Rezoning Transportation Analysis

Petition Number: #2021-198

General Location Identifier: Tax ID 18712322

Date	Description
12-23-21	First Review (WB)
11-23-22	Second Review (IW)
02-22-23	Third Review (IW)
03-28-23	Fourth Review (IW)

REZONING PETITION 2021-198

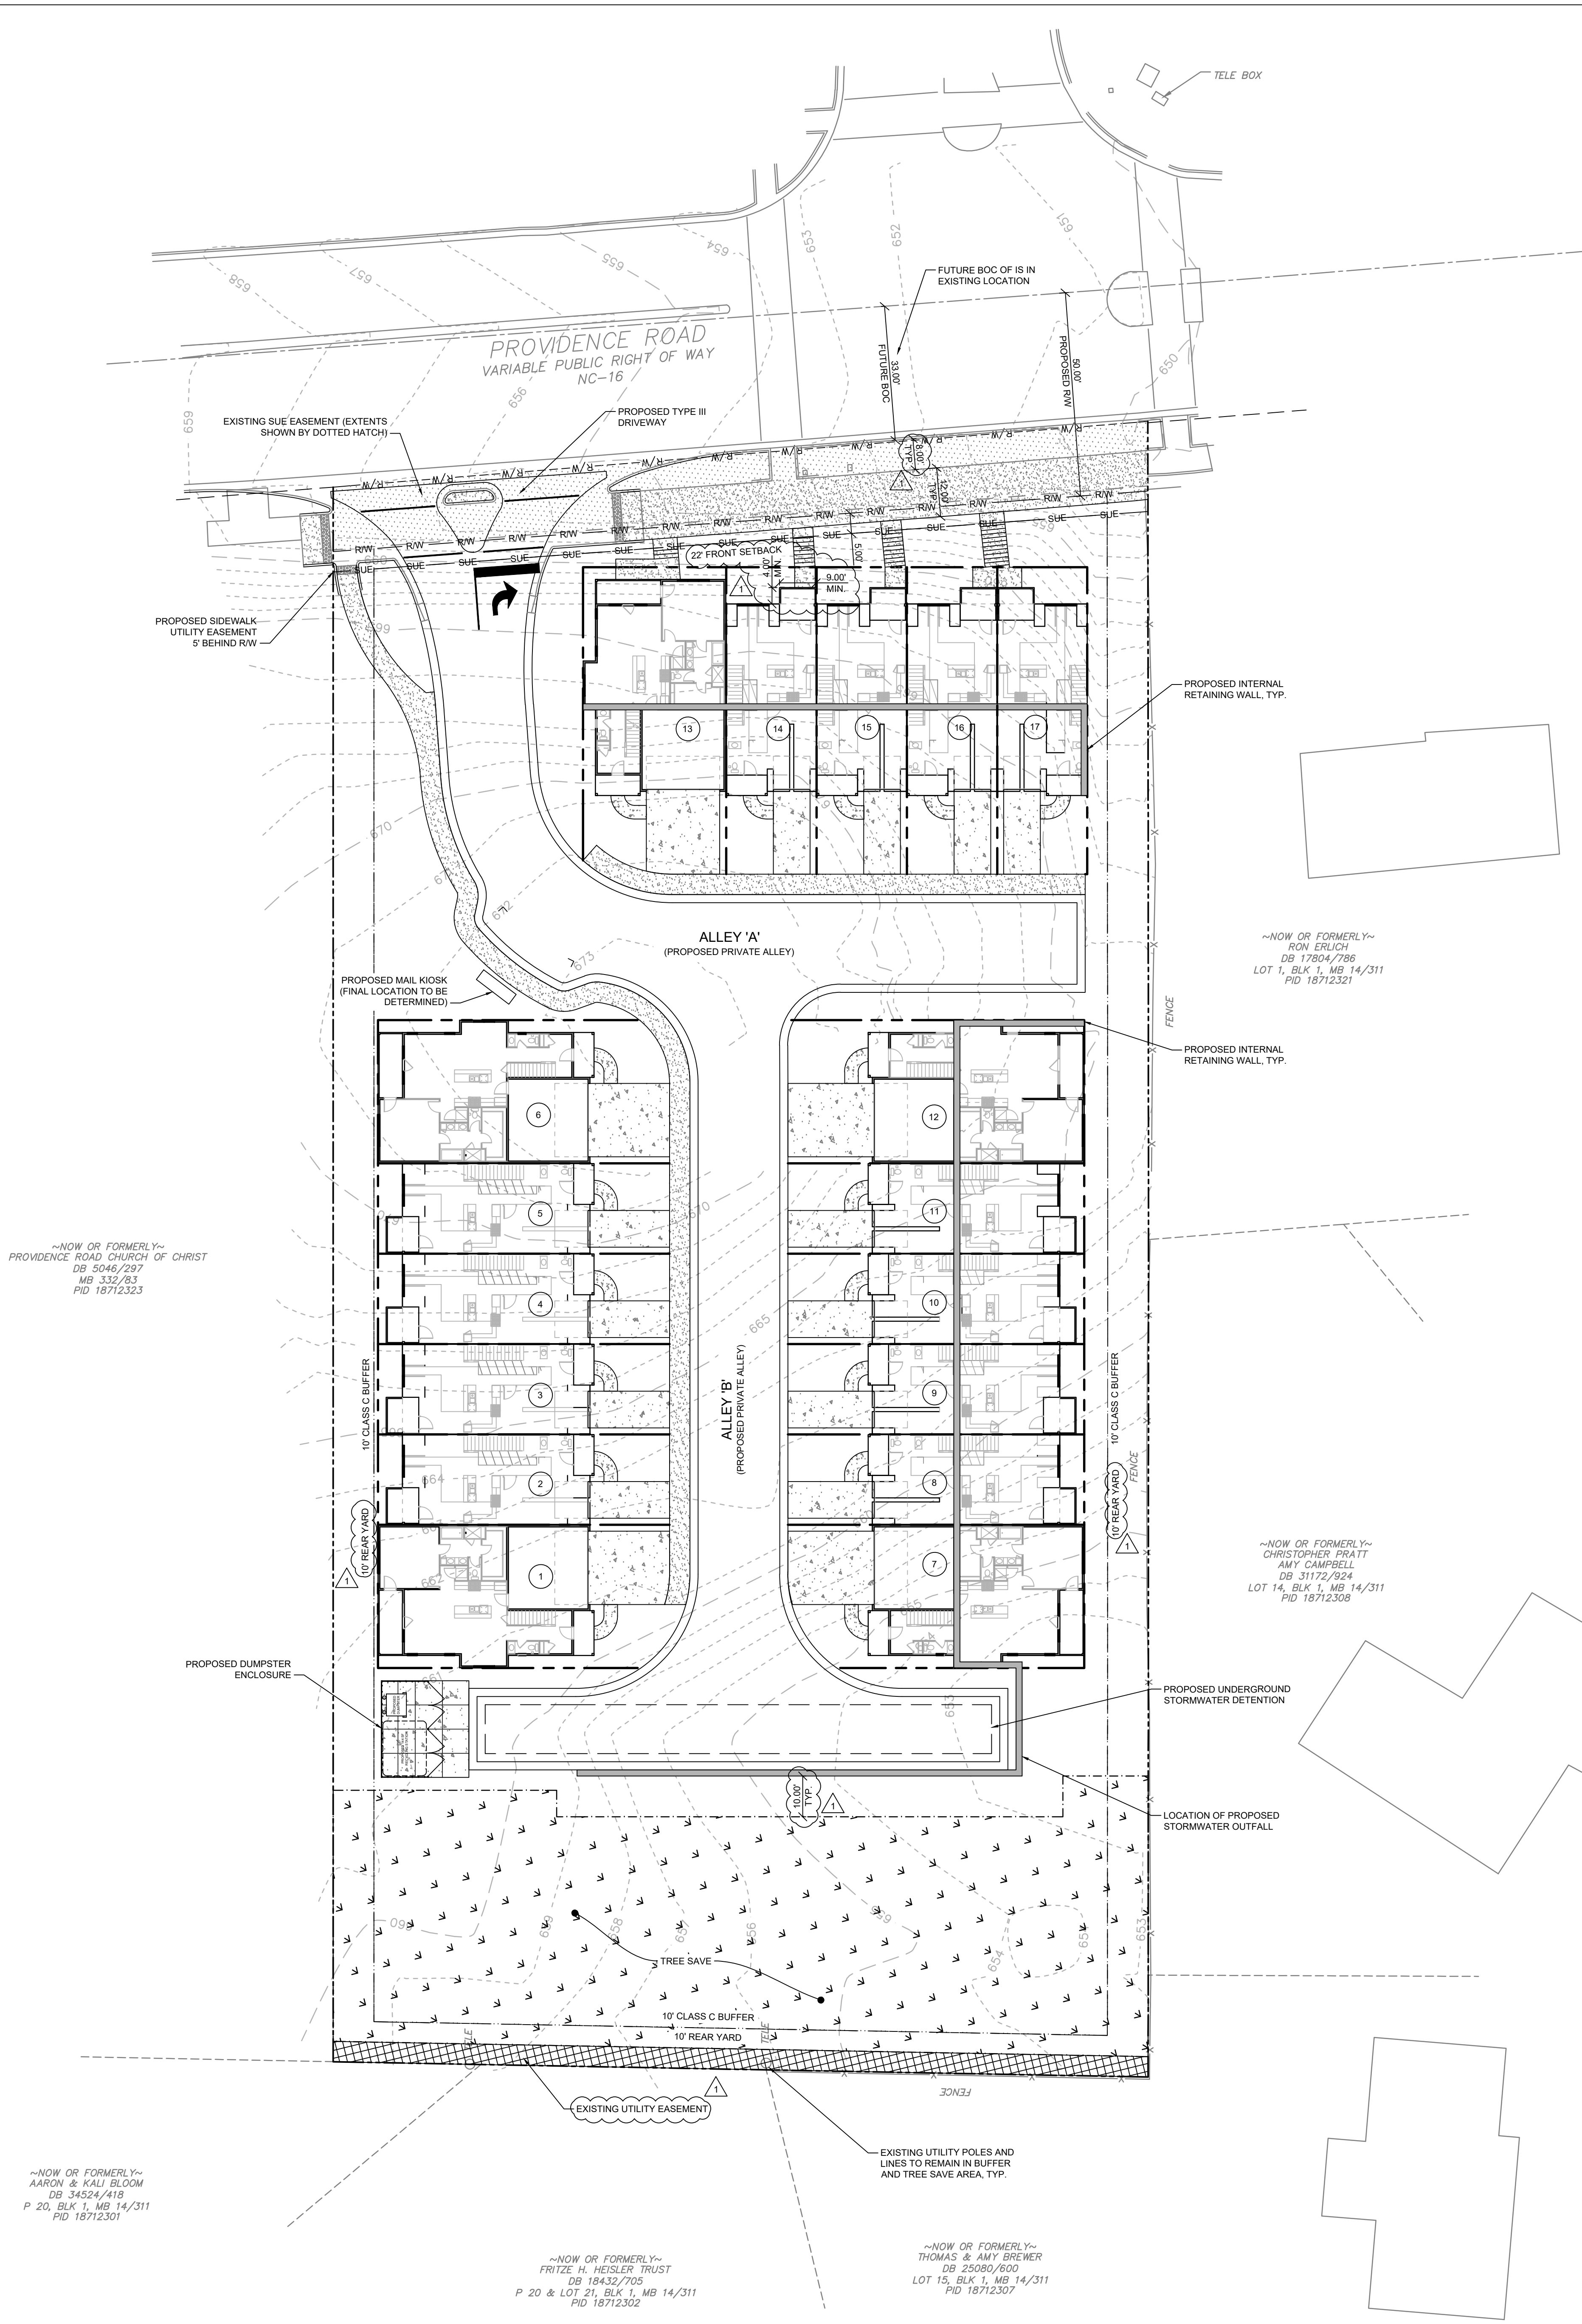
Clarifying comment 2-22-23: Per email exchange on 1-23-23, CDOT has informed the developer that the future back of curb is 33' from centerline. Site plan is currently showing 30' and suggesting the current curb and gutter is in the future location, this is incorrect. Adjust planting strip and 12' MUP accordingly.

3. NCDOT will not allow this private driveway to have full access at this existing signalized intersection. NCDOT recommends a right in right out (RIRO) limited access north of the signalized intersection.

4. ~~Outstanding Comment from 12-23-21~~ Revise site plan and conditional notes to commit to dedicate 50 foot right of way from the Providence Road centerline. The site plan shall label and dimension the right-of-way from the road centerline. (refer to Note 6. figure)
5. **Outstanding Comment from 12-23-2021** Site plan and conditional notes revisions are needed to commit to construct bicycle facilities by installing a 12' multi-use path with an 8' planting strip to meet the City of Charlotte BIKES Policy.

Clarifying Comment 2-22-23: Site plan to include conditional note as well committing to an 8 foot planting strip and 12' multi-use-path.

8. ~~New Comment Based on 11-04-22 site plan:~~ The relocated driveway now creates a conflict with access to building. Revise and update site plan so that ramp leading to driveway access does not conflict with access to building.
